Department of Transportation

February 26, 2020

SH94
El Paso County

RE: Ellicott Town Center 02.26.20 - SF1910_SF1825 - Commercial Replat, Plat review (Plat Comments Updated, pg 2)

DRAWING: 18026FP.DWG PAGE 4 OF 4

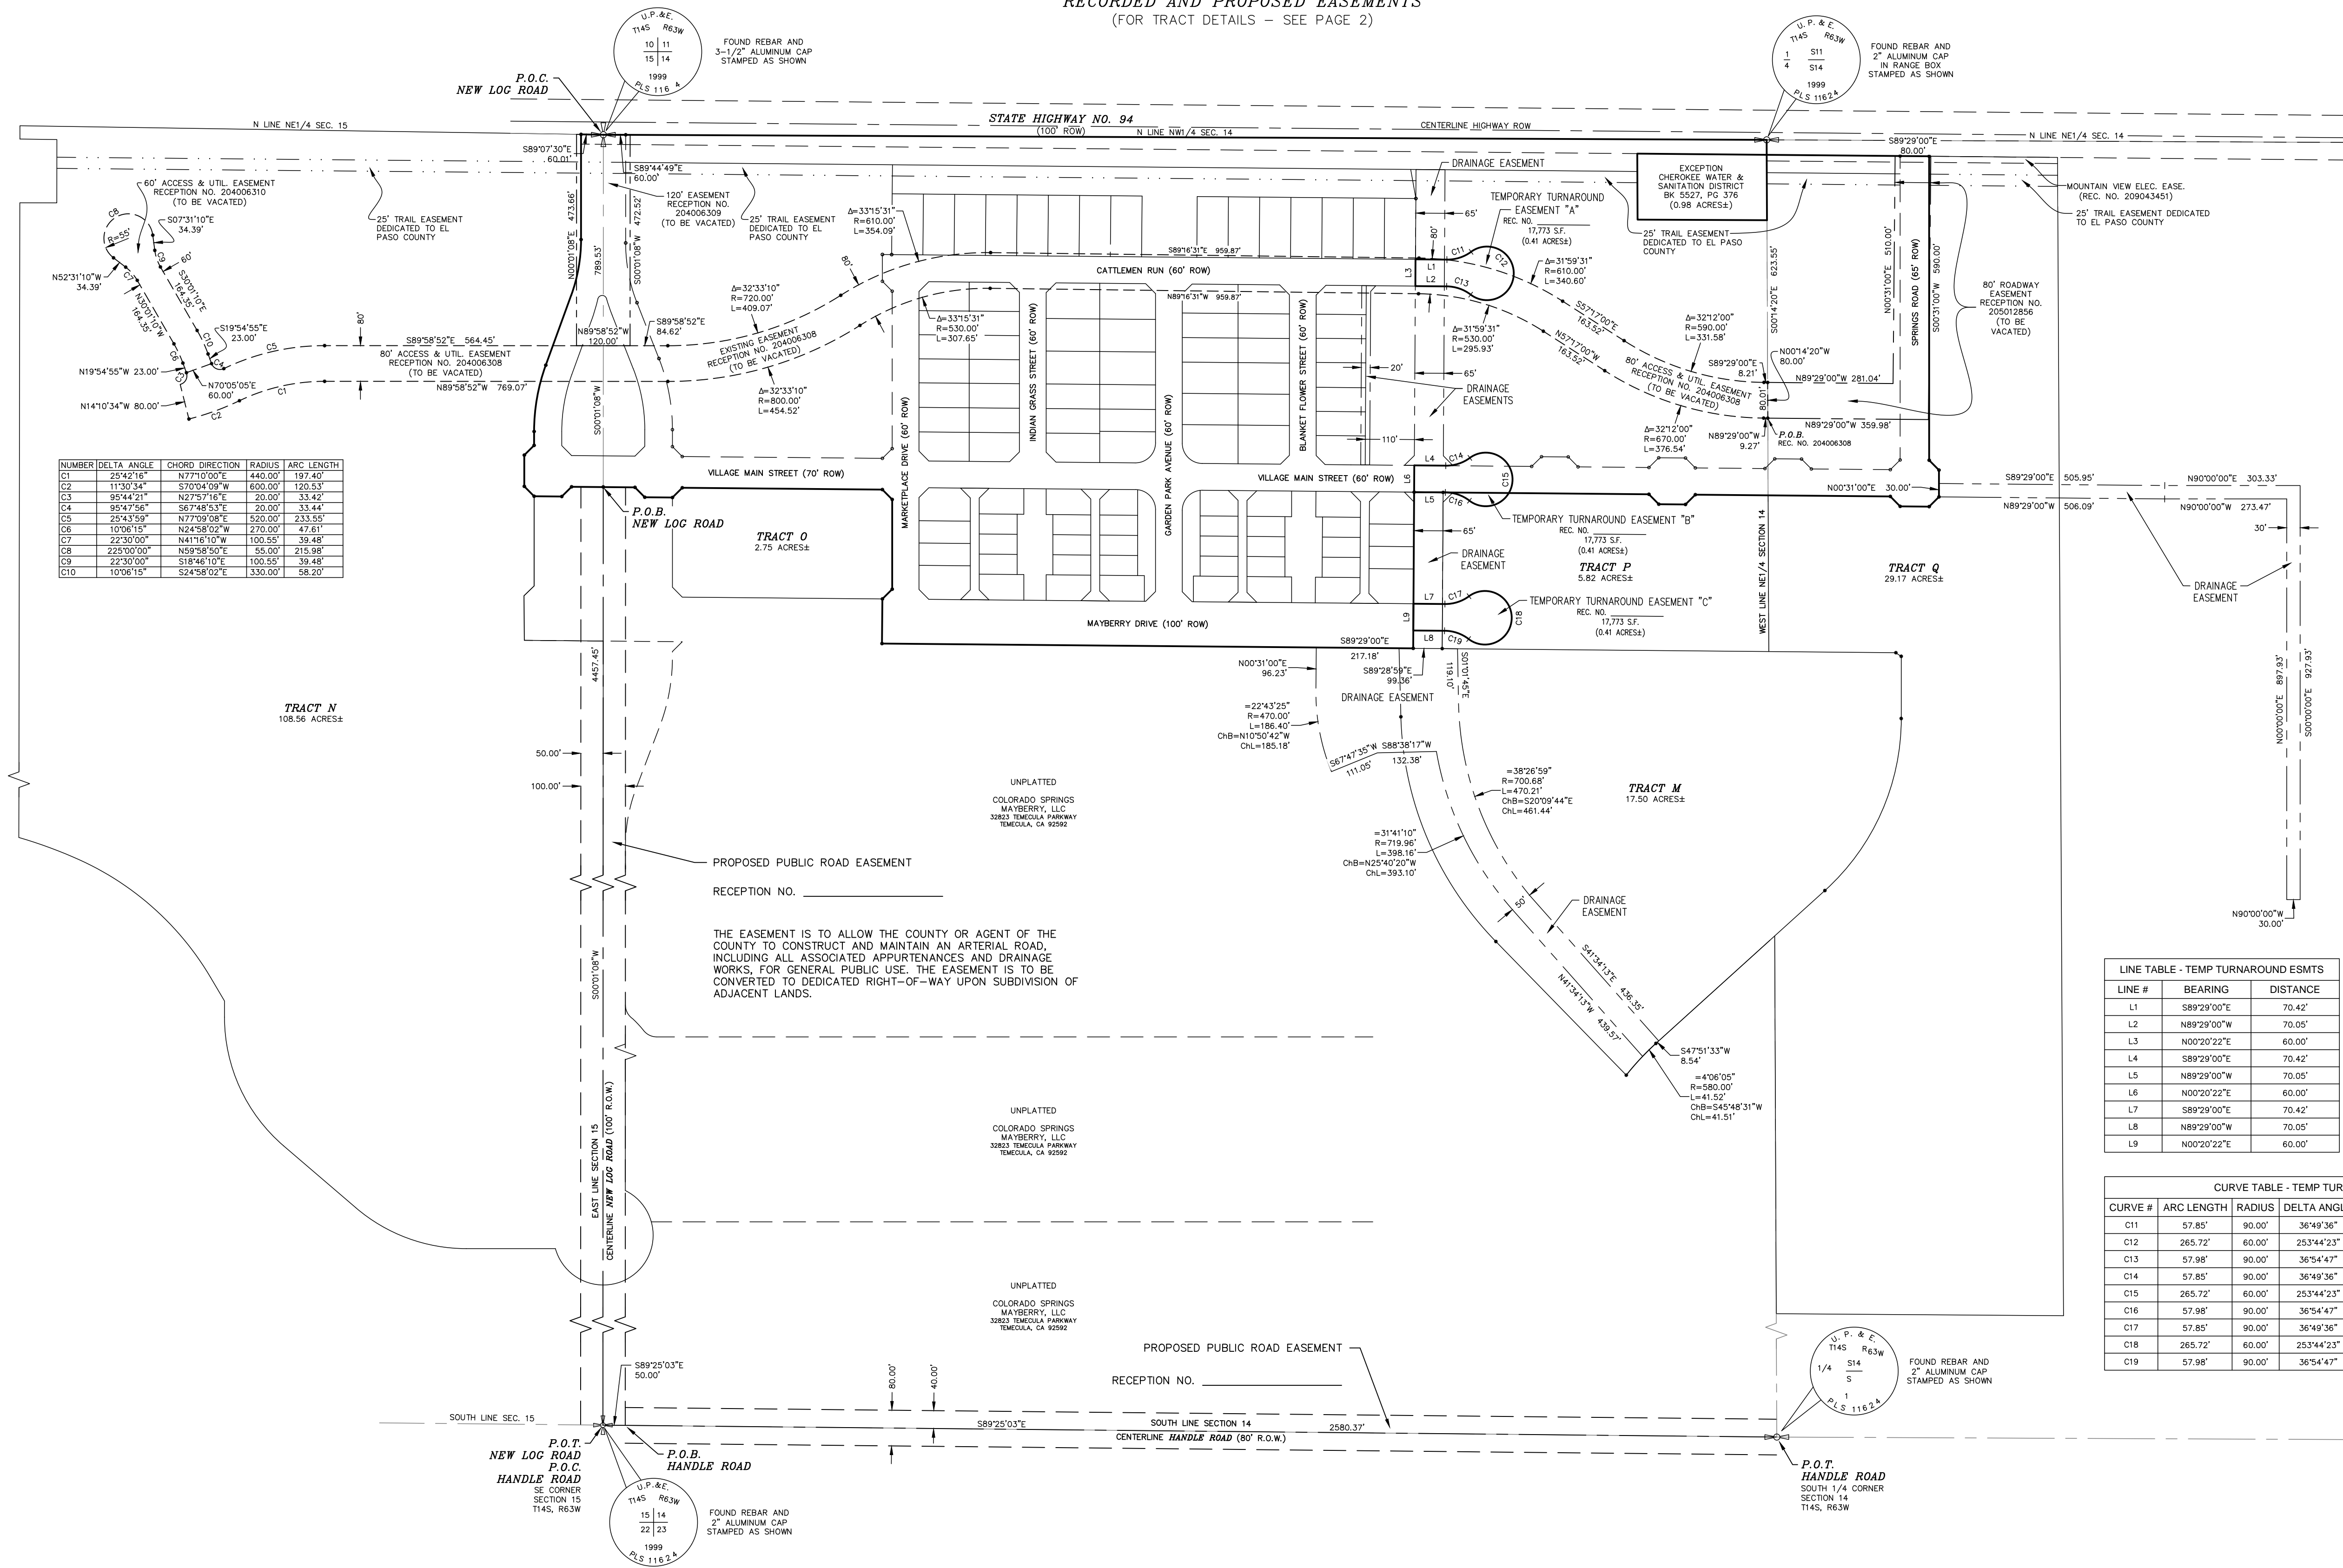
- c. On the plat, Change the dedication text within the 40' ROW to read "40' Dedicated ROW to Colorado Department of Transportation". **Please revise**

- d. Once CDOT receives the descriptions, CDOT will prepare the deed's for recording. The deeds will be given to the subdivider for recording. Add the reception / recording numbers to the note "40' Dedicated ROW to Colorado Department of Transportation" within the 40' section on the plat before the plat is recorded. I'm not sure if this is possible due to timing, but having the numbers on the plat would be ideal for research and record keeping. **Please revise**
